RE: THOMAS STREET CAR PARK SITE CHATSWOOD MP09_0066 MODIFICATION 14

I refer to your advice regarding proposed Modification 14 to MP09_0066 for the mixed use development on the Thomas Street Car Park Site in Chatswood by Karimbla Construction Services (NSW) Pty Ltd.

A-0104 G
SECTION 75W SUBMISSION

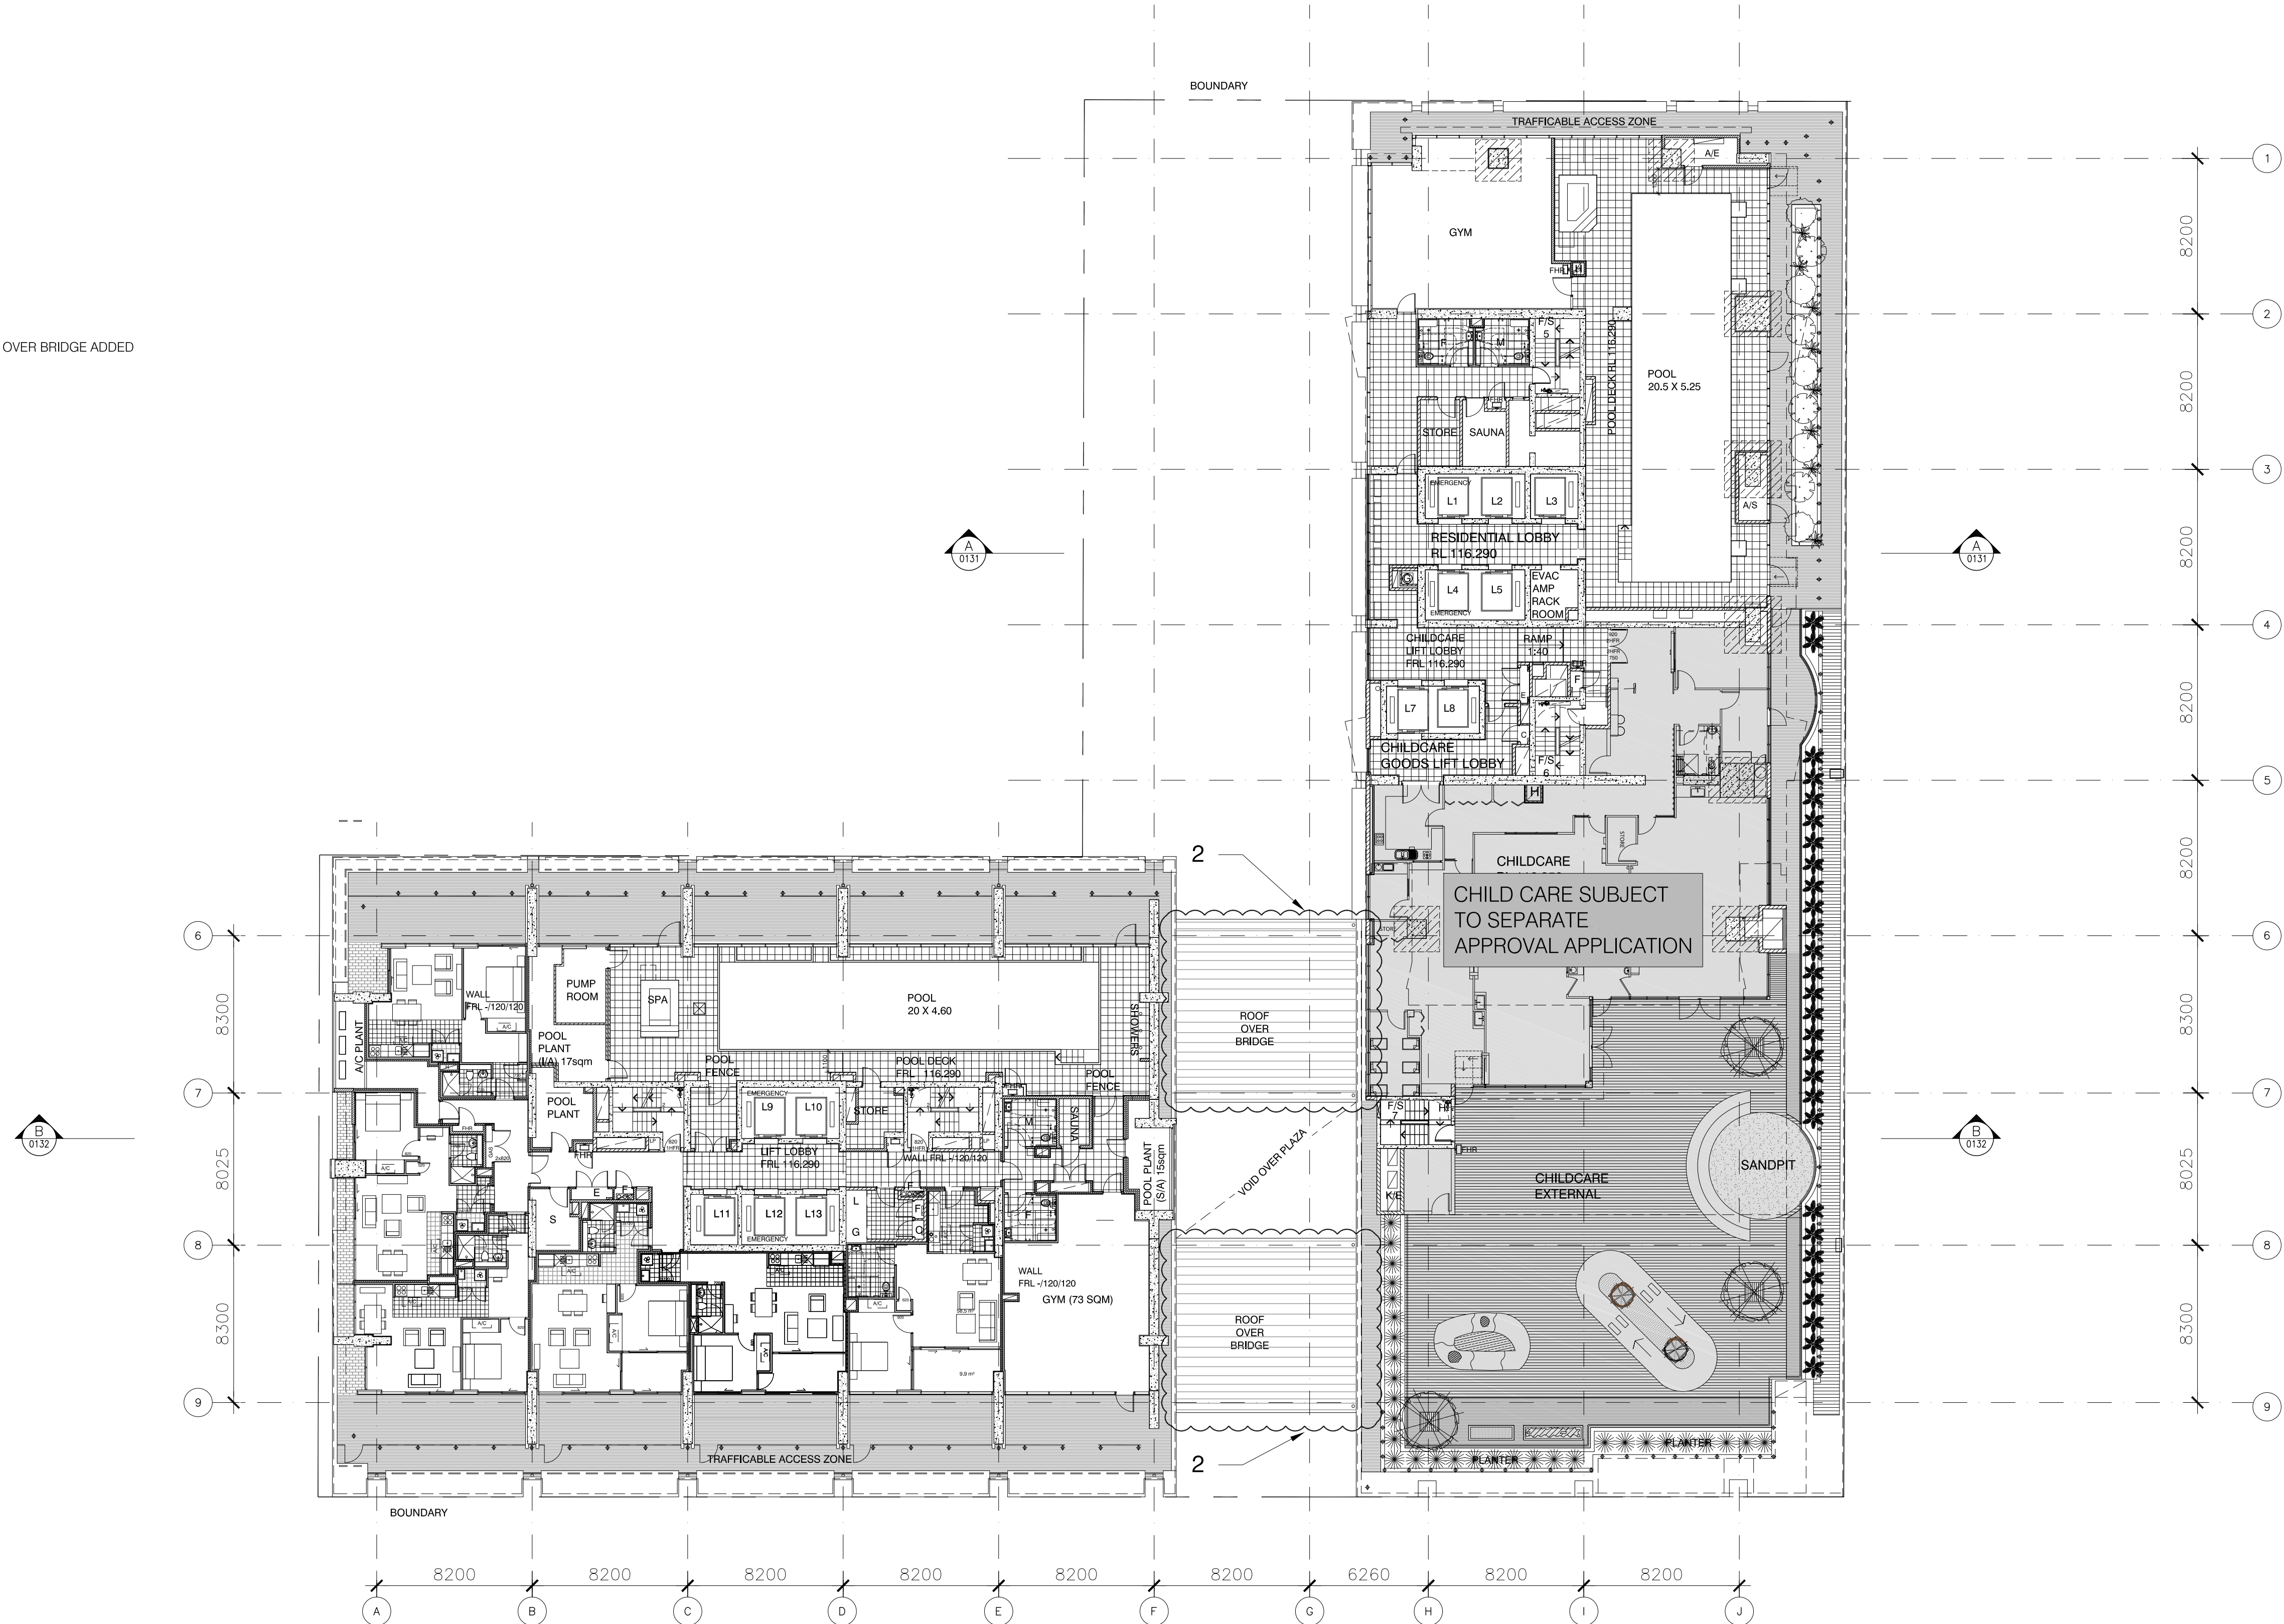
The second matter in the modification proposes to enclose the bridge connections between the two buildings at levels 1, 2 and 3 to enable weather protected access between the building on those levels for vehicles and pedestrians. The enclosing of the bridges is proposed by provision of a light weight roof over each bridge and provision of glazed walls. It is not indicated whether the glazed walls will be translucent or clear glazing.

Council considers that the glazing should provide an etched pattern or motif in the elevation of the glass walls facing Thomas Street and the plaza and Albert Avenue. This should be required to be provided as an additional detailed design plan. The objective is to maintain the architectural presentation of the facades as contemplated in the consent, as well as provide an additional contribution to the public art on the site and the design that may complement the theme of the sculpture proposed on the Thomas Street frontage.

A-0100 J
SECTION 75W SUBMISSION

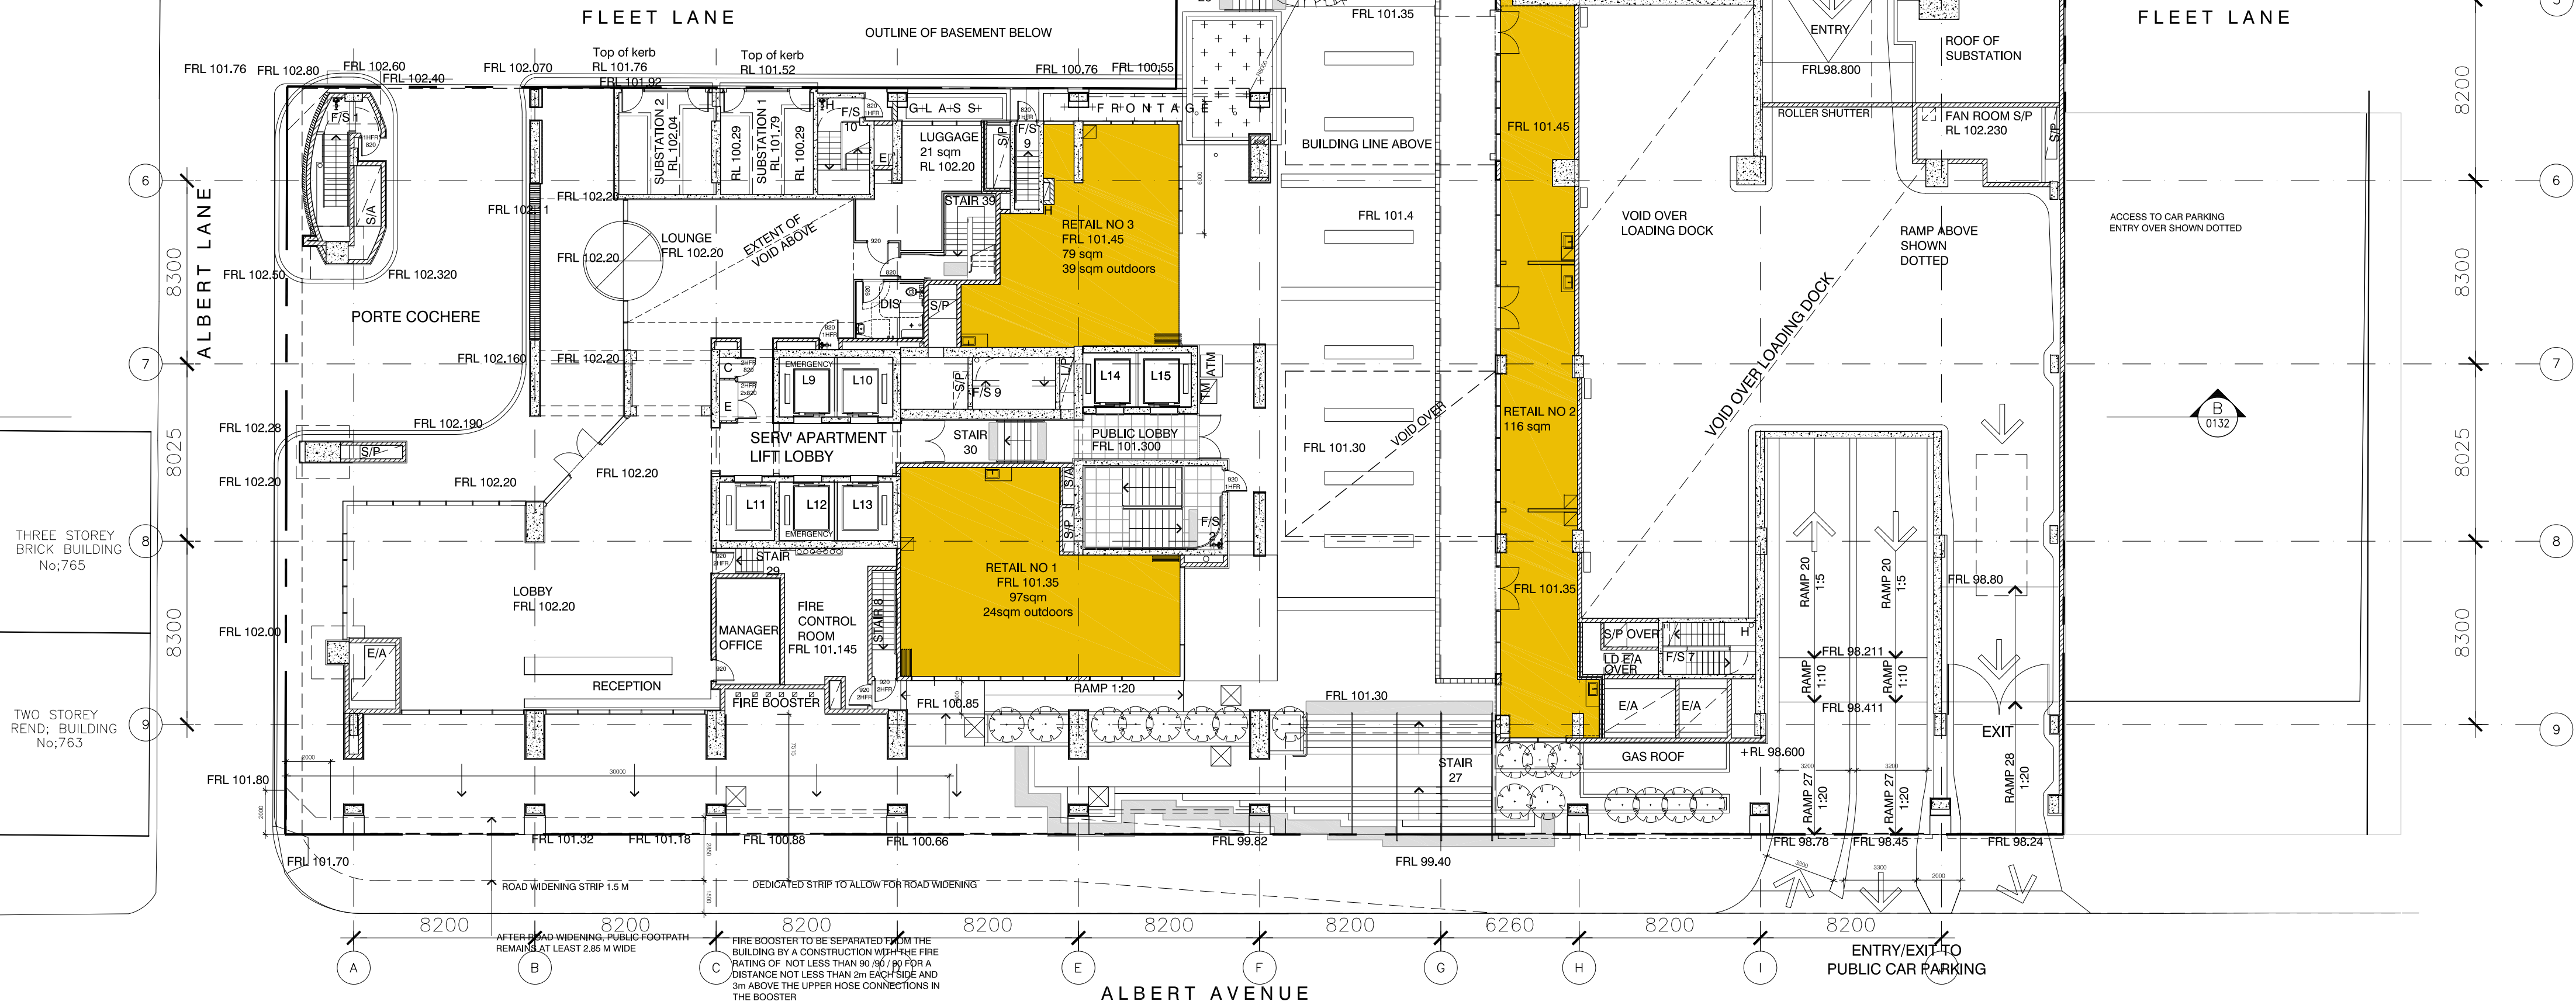
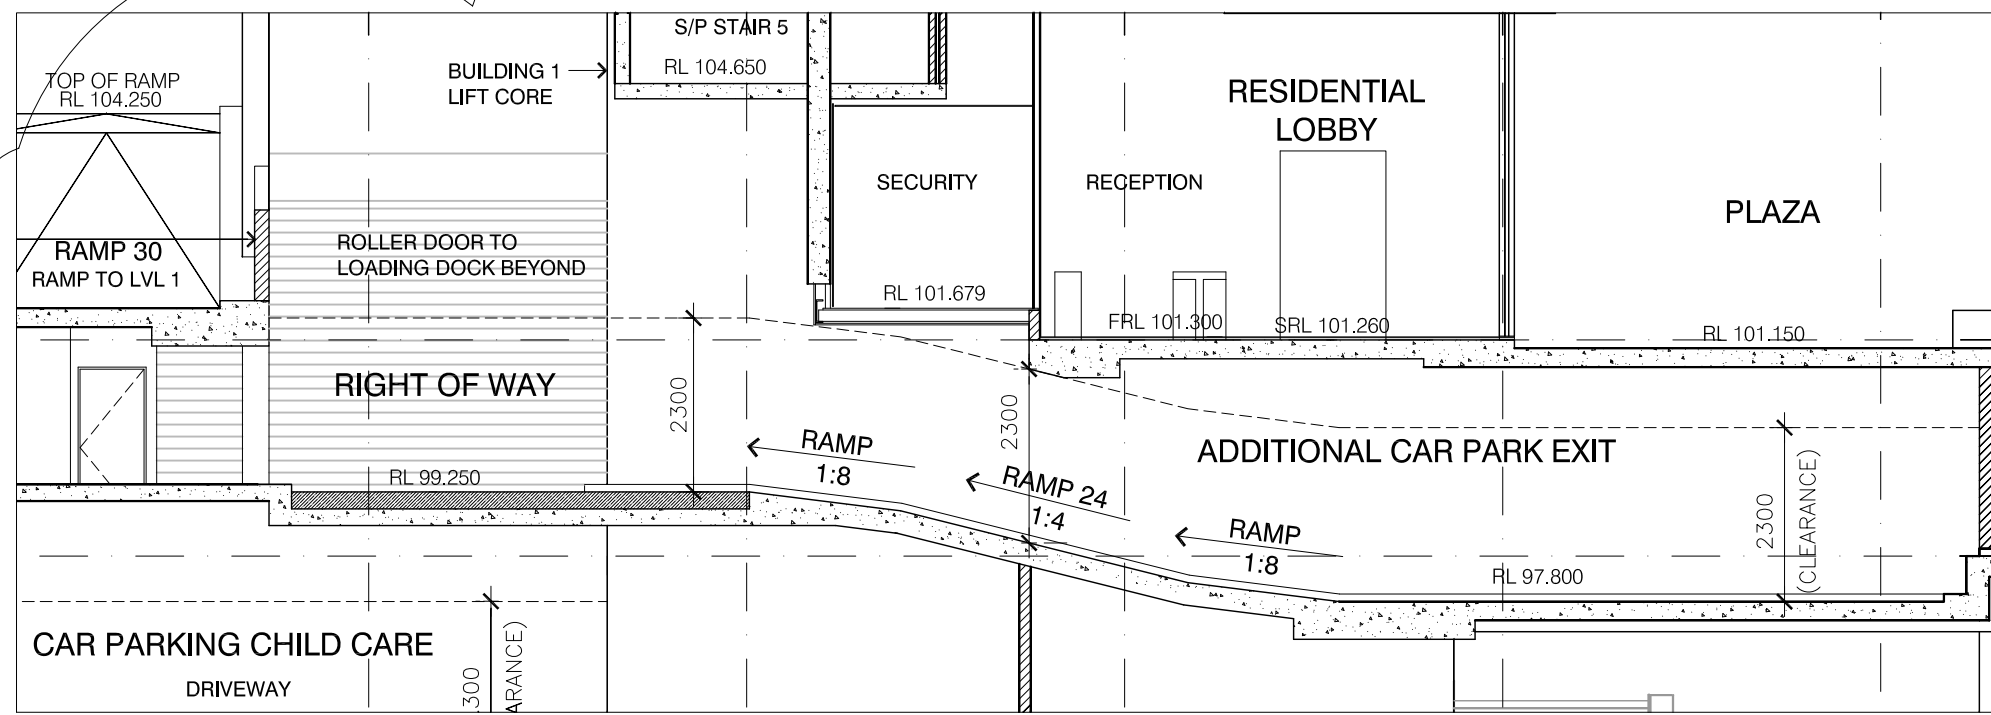
I note the first matter in the modification proposes increasing the residential lobby area and provision of a security room at the rear of the relocated reception desk. The security room located at a higher level is accessed by stairs as a consequence of the change in level. The change in level is required to provide adequate clearance above the basement car park exit ramp. The consequence of the change is that:

- The clearance above the ramp may not be adequate for a B99 vehicle noting the exit will be used by residents and tenants as well as the general public using the Council public car park and may not comply with Australian Standards, and,
- The change in level may not be acceptable noting that disabled access will not be possible to the security room and this is contrary to disability access requirements.

Council also notes that there is a level change between the residential lift lobby and residential lobby reception area in addition to the change in level of the security room. It is not clear in the plans how the connection is dealt with. I note that the various plans lodged for the various modifications have markings or rendering over the plans so that the detail of the plans has been difficult to read.
